From: Grant, David
Sent: 21 July 2023 09:07
To: _planningadvice
Subject: FW: Wests Nurseries H16-0574-23
Attachments: We sent you safe versions of your files; 660 - 2023_07_19 Surface Water Lagoon Details.pdf

SURFACE WATER DISPOSAL AT WESTS NURSERIES, MALLARD ROAD,
LOW FULNEY, SPALDING, PE12 6ND.

DETAILS OF SURFACE WATER LAGOON

REVISIONS		BY	DATE
DRAWN	MW		14/6/23
SCALE	1/500	1/1250	CHECKED
CLIENT	West's Nurseries Ltd 20 Mallard Road Low Fulney/ Spalding Lincs PE12 6ND		
PROJECT	Proposed storage lagoon to provide attenuation for glasshouses constructed in 2011		
DETAILS	Location & Block Plan

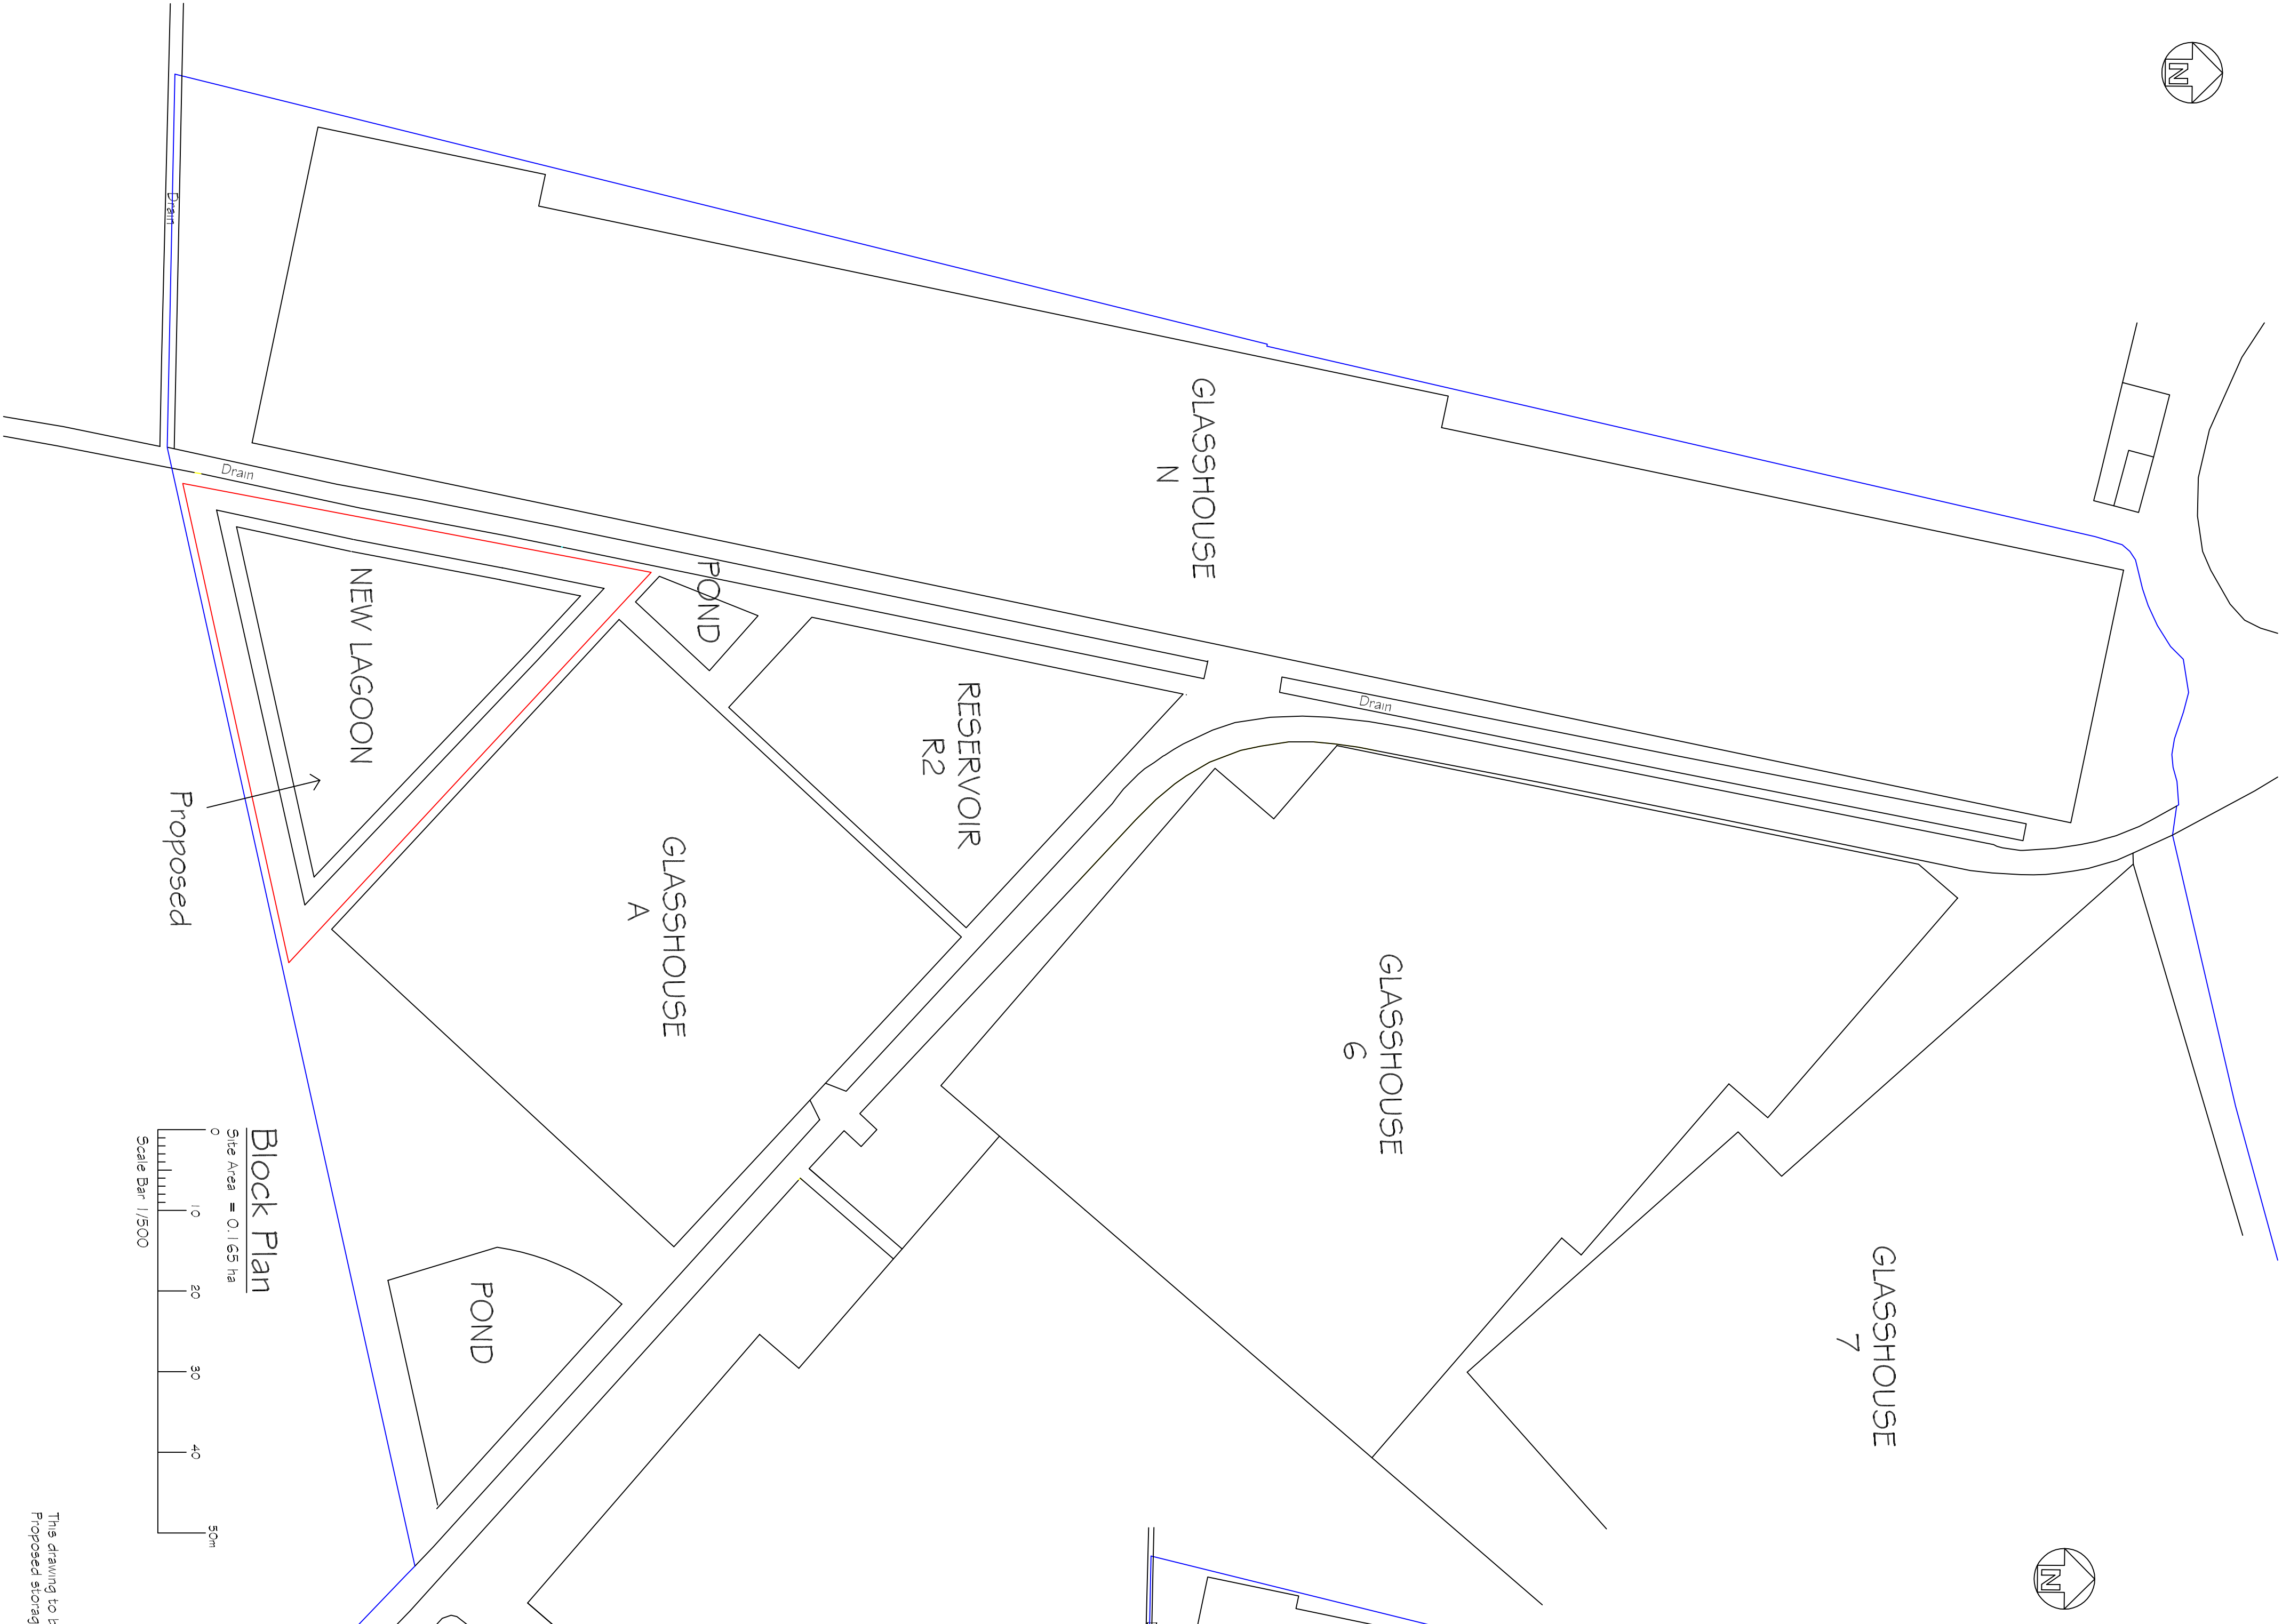
I hope you are well. A description of the proposed lagoon dimensions is provided on supporting information, however, no profile drawing of the lagoon has been submitted, solely drawings from above. I have discussed this matter with the Planning Manager and he is in agreement that a profile drawing should be provided, as well as details of how the lagoon will be made safe, such as boundary fencing and/or an escape ladder.

As the surface water lagoon is not a lined storage lagoon where water is stored (a deep water lined storage lagoon already exists on the site and does have a boundary fence around) the applicant does not feel the need for any boundary fencing but would provide escape steps

The required dimensions of this lagoon have been designed in a separate document. The lagoon will be formed by excavating the triangular area south west of the existing glasshouse 1.0 metre deep with side slopes with a slope of 1.5 to 1.0 (approximately 34 degrees to the horizontal). The angle of the side slopes will be similar to the batter of the dyke on the western side of the lagoon.

The lagoon will not be lined. The side slopes and base will be grassed which will be managed along with all of the grassed areas on the site.

The lagoon has been designed only to receive excess water from the existing lined reservoir on the north western side in heavy rainfall situations. At the present time it may only be filled with water for a period of a few days every 3 to five years, and therefore for 99% of the time the lagoon will be empty.
